# DRAINAGE LETTER

## **ROLLING THUNDER BUSINESS PARK FILLING NO. 2**

SUBJECT: Drainage Letter  
Rolling Thunder Business Park, Filing No. 2

Transmitted herewith for your review and approval is the drainage letter for the Rolling Thunder Business Park, Filing No. 2, which is a replat of Lots 2 and 3, Rolling Thunder Business Park. It has been revised per the reviews by Mr. Daniel Torres, 5-11-20 and 7-31-20.

National Flood Hazard Layer FIRMette

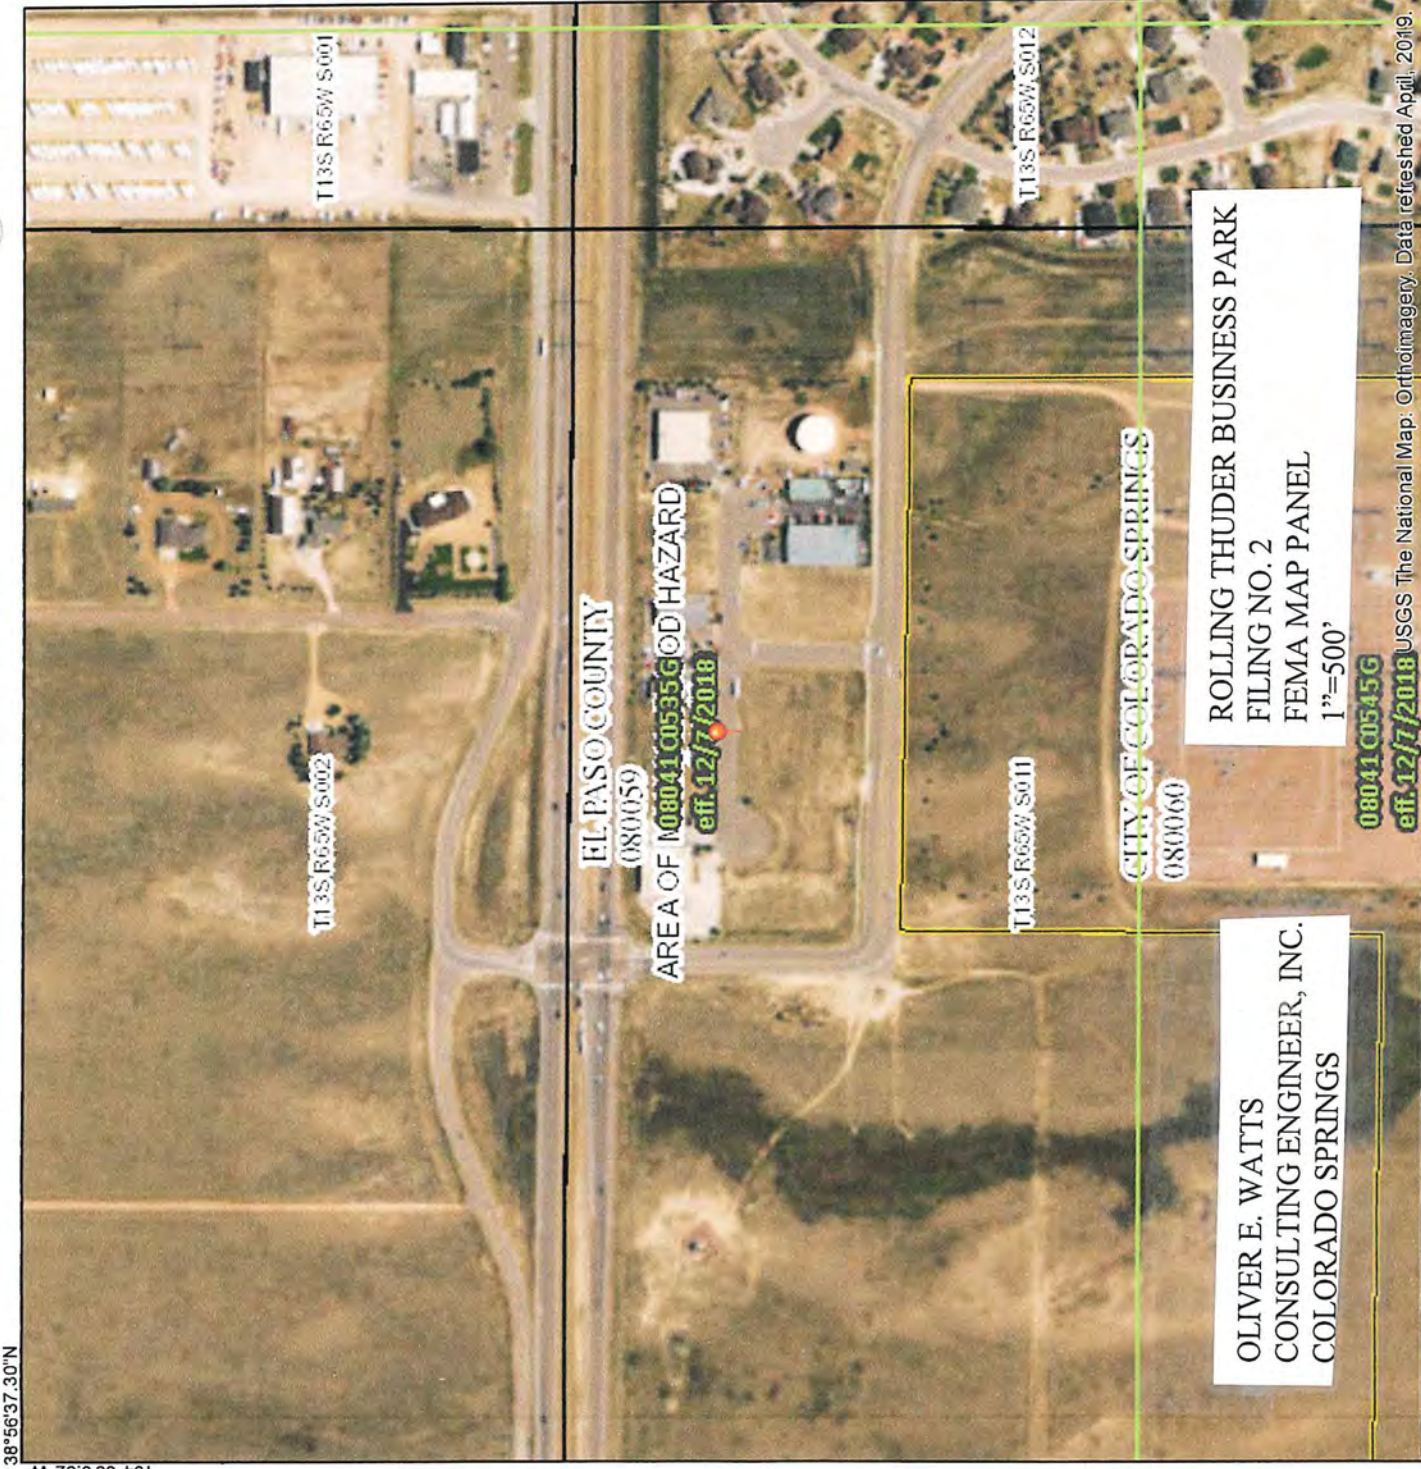
The attached FEMA FIRM map indicates the panel no. as: 08041C0535G  
Please revise

PEAK GYMNASTICS
 APPROVED DRAINAGE PLAN
 11/2018 M&S CONSULTANTS
 PCD-PPR 18-035

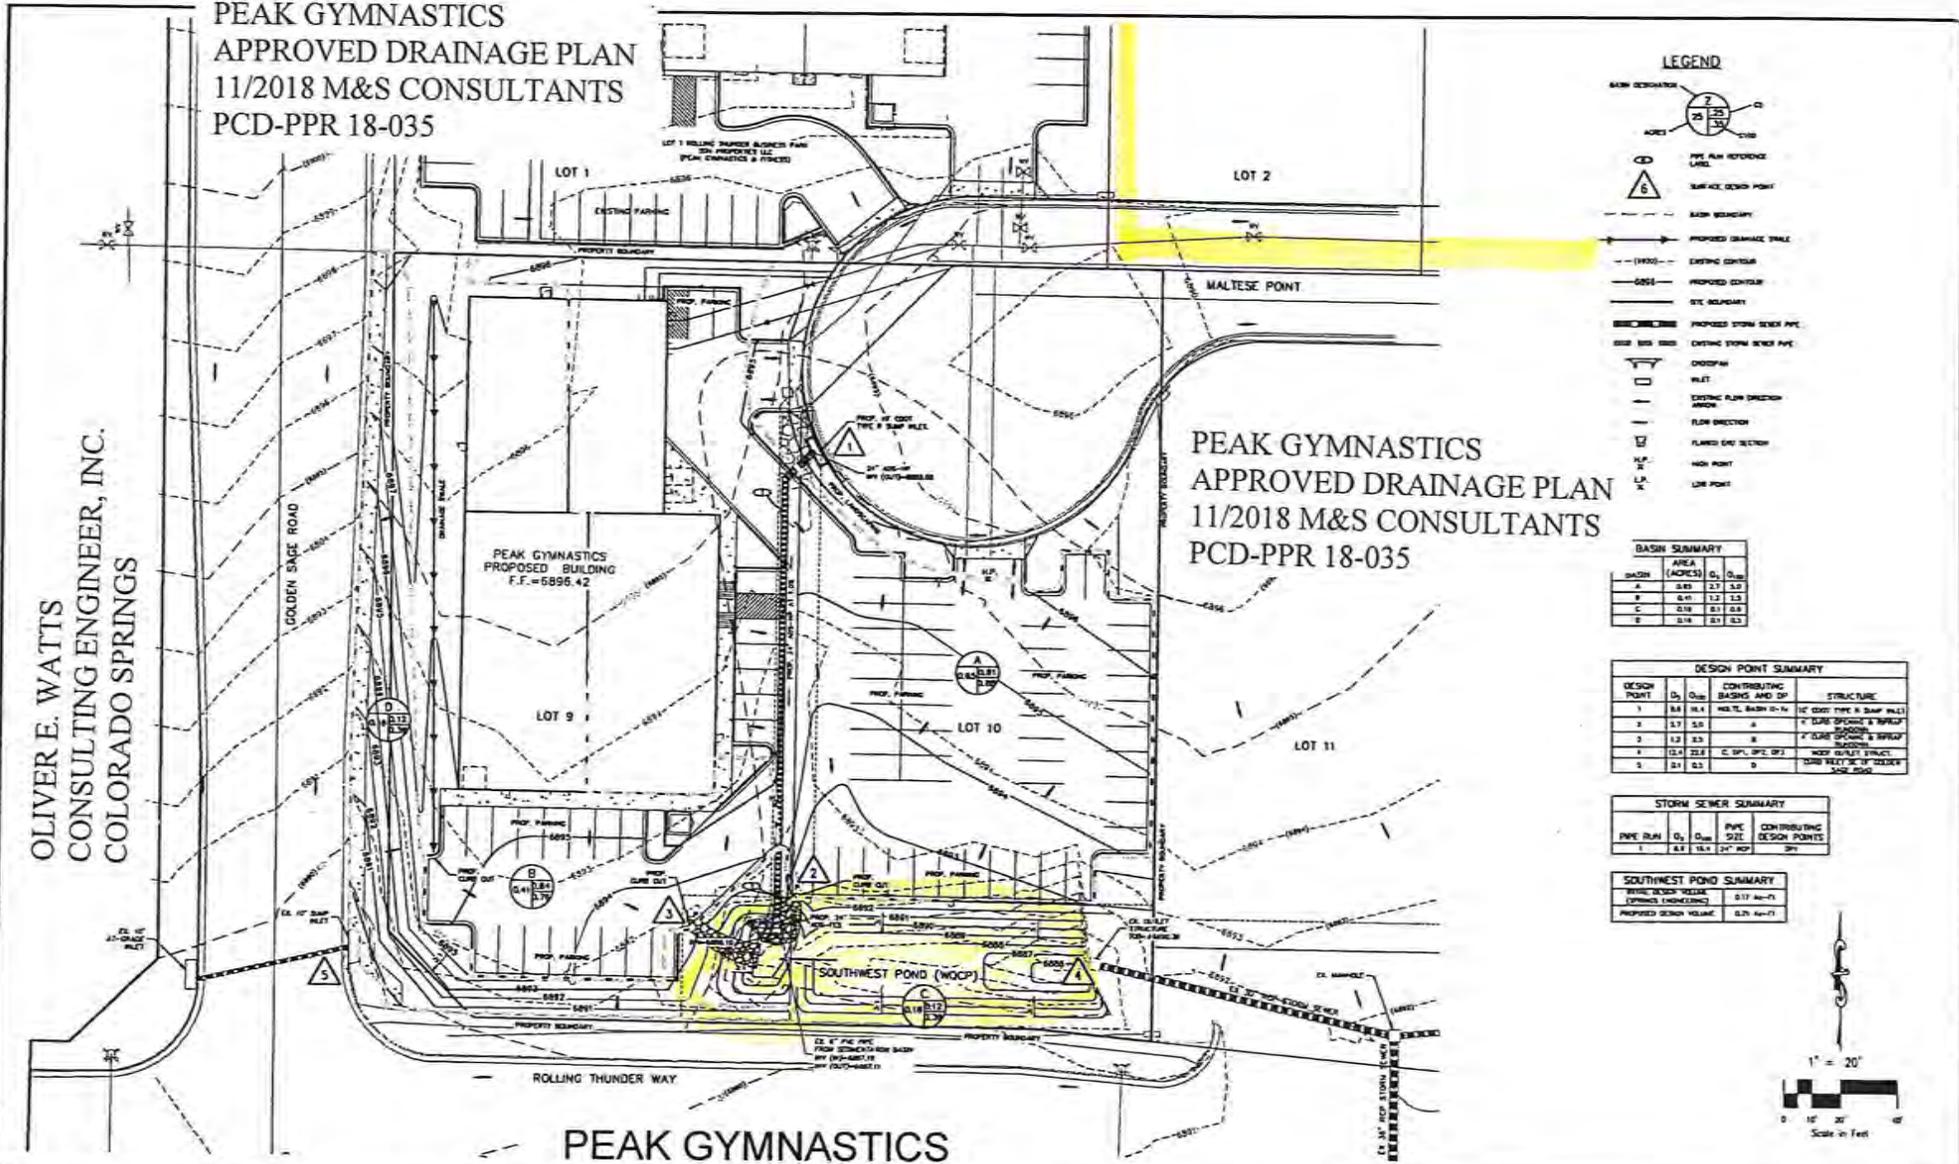
Please highlight and label the existing ponds that your developed flows are going to.
